Alterations to existing Wendy's restaurant to meet Wendy's latest design and branding standards and to address demand and restrictions of the ongoing pandemic.

FORM P3: ADMINISTRATIVE DECISIONS AND MINOR AMENDMENTS

Re: Wendy's Restaurant located at 410 Eubank Blvd. N.E.
Building Permit **BP-2020-46002**

From: [Kristopher Schiffer](#)
To: [Gould, Maggie S.](#)
Subject: Re: AA for WEndys at 410 Eubank NE
Date: Sunday, December 6, 2020 4:43:08 PM
Attachments: [image001.jpg](#)
[image.png](#)
[image.png](#)

SHEET NUMBER  
**AS1.1**

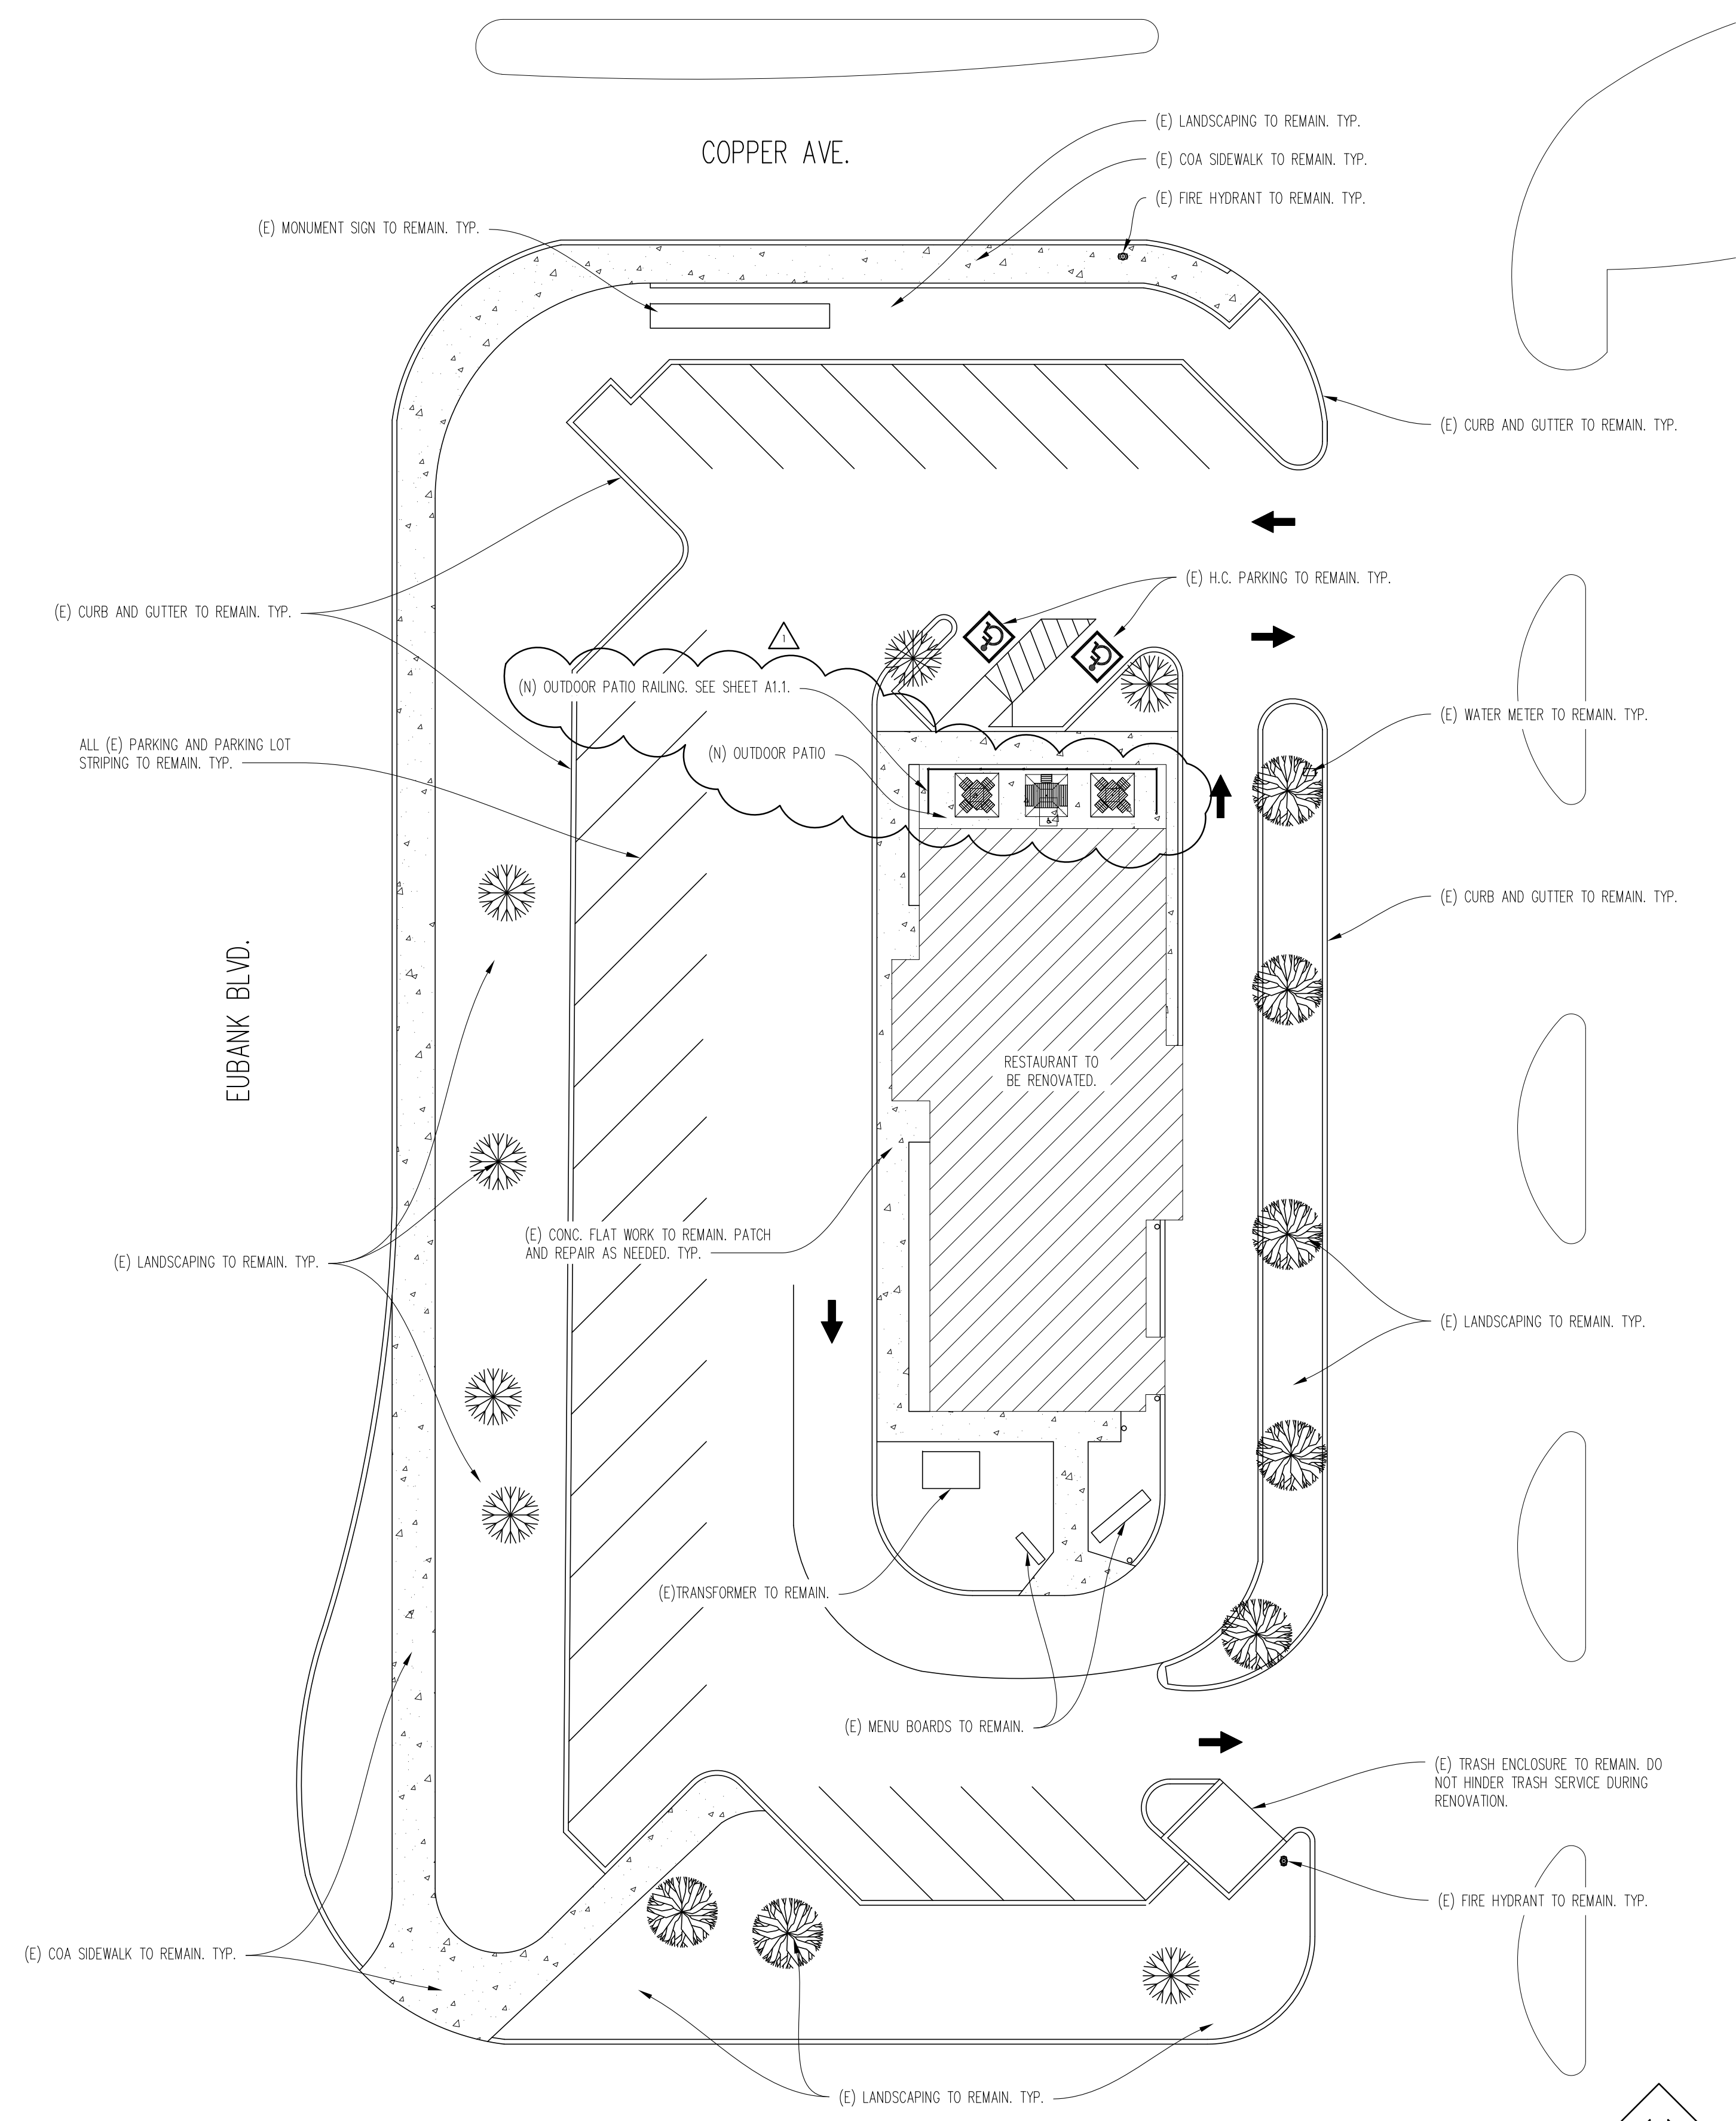
I am review your administrative amendment This site. Can you please clarify the change in square footage from the original approval to your proposal. It looks like you are adding outdoor seating to the northside of the building and removing landscaping. Please clarify the change in landscaping square footage, the landscaping cannot drop below the minimum requirements on the site plan . All changes need to within 10% of the original approval.

Also, the site zoning MX-L, that should be noted

The landscaping is not changing at all as we are removing the solarium addition and dedicating that space to the new outdoor dining area. Please see attached illustrations:
